Application No: R/244/20/HH
Site Address: 21 Worthing Road Rustington BN16 3JU
Description of works: Single storey rear extension and rear first floor roof extension.

Thank you for your internet representation made on 18th January 2021 which has been recorded as no objection with the comments as follows:

PROPOSED FIRST
FLOOR PLAN 1:50

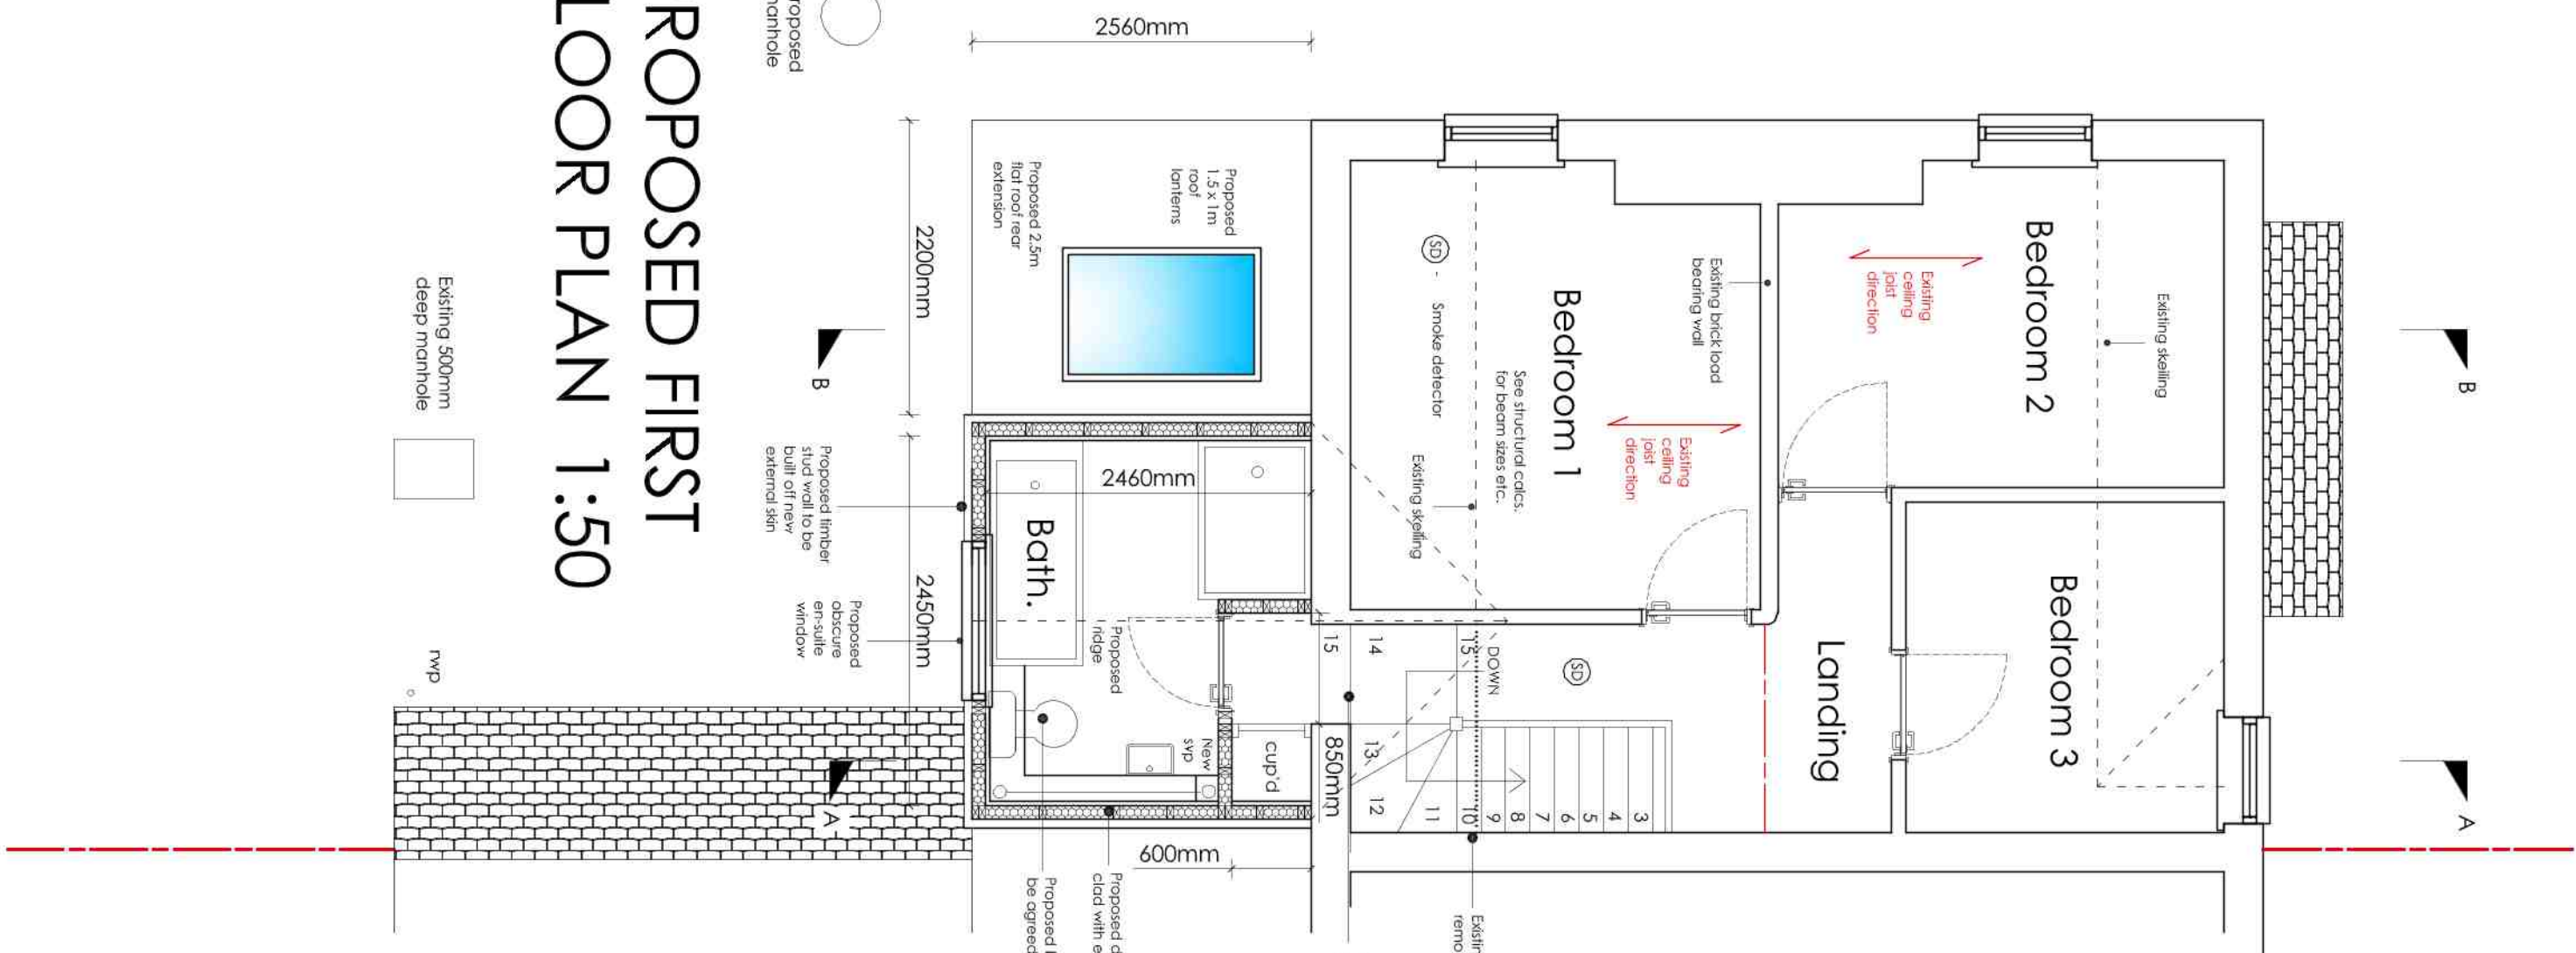
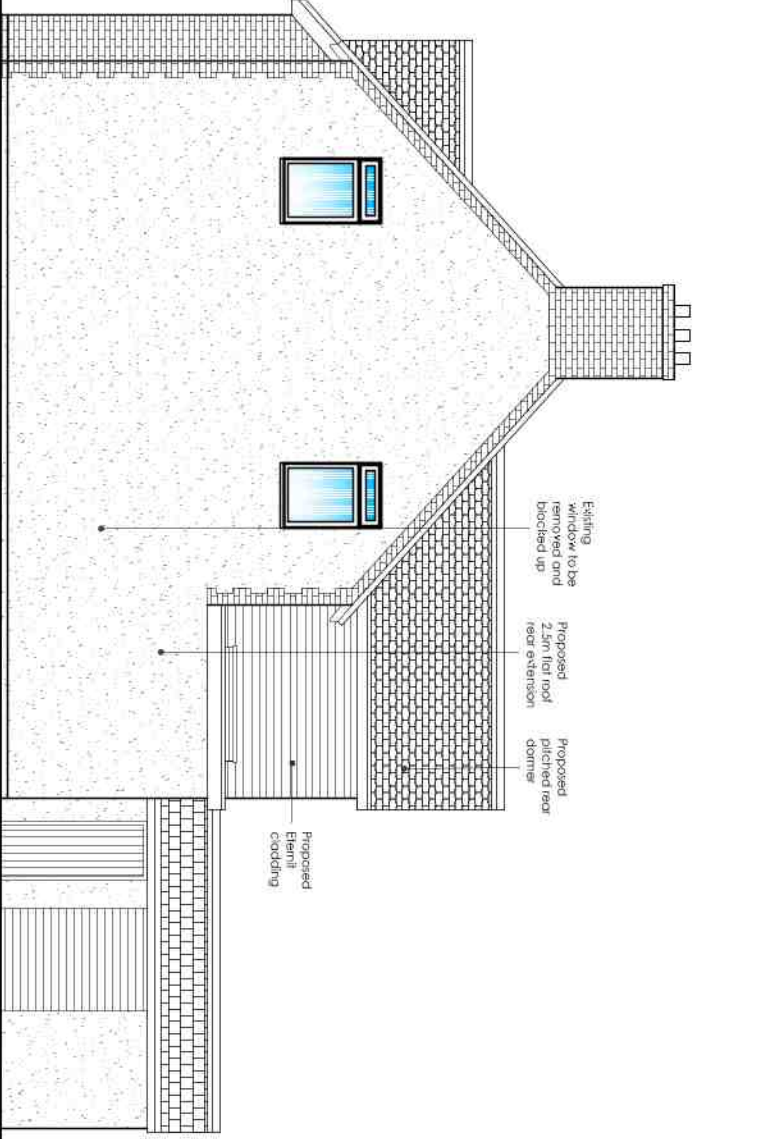
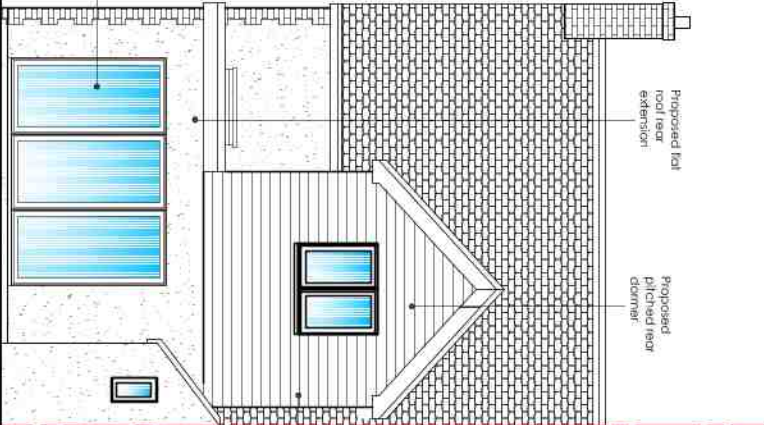
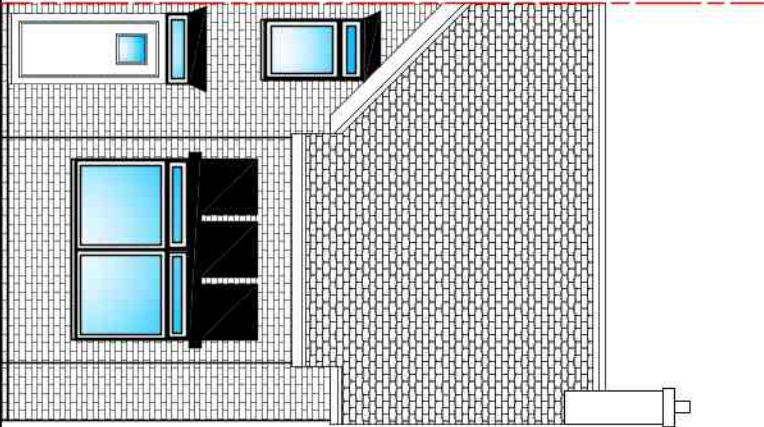
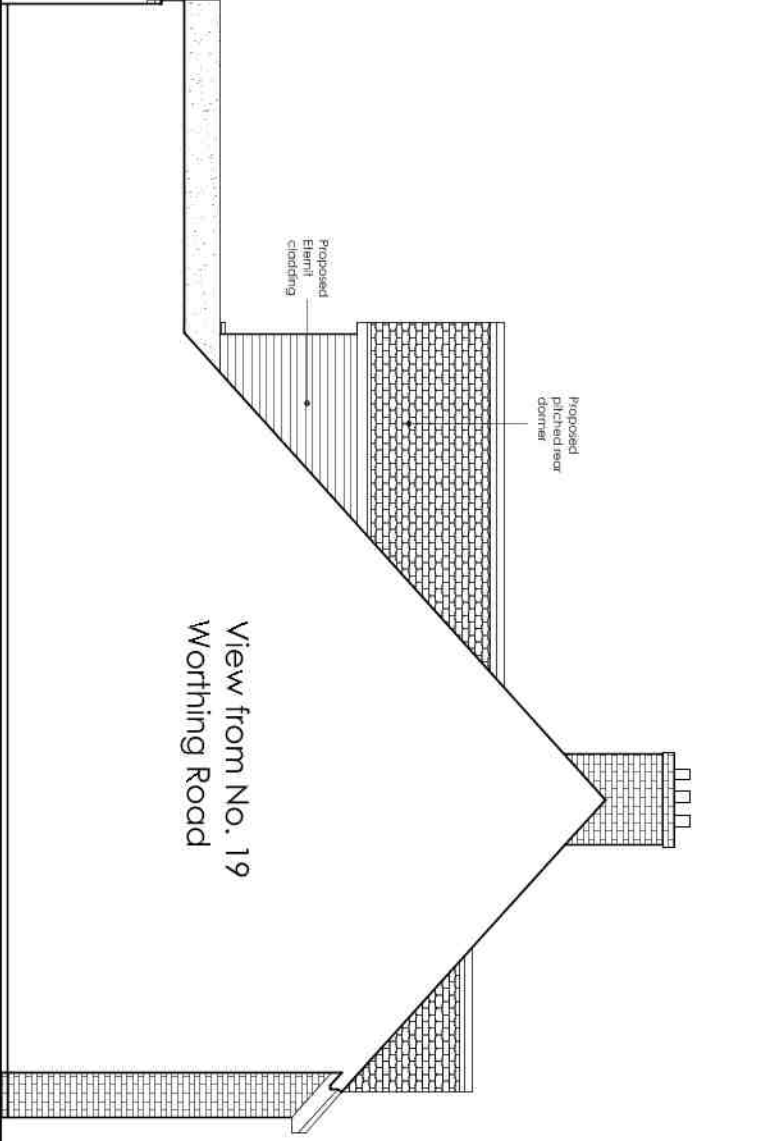
My Council has noted the above application and wishes to raise no objection to it, subject to the first-floor windows being opaque.
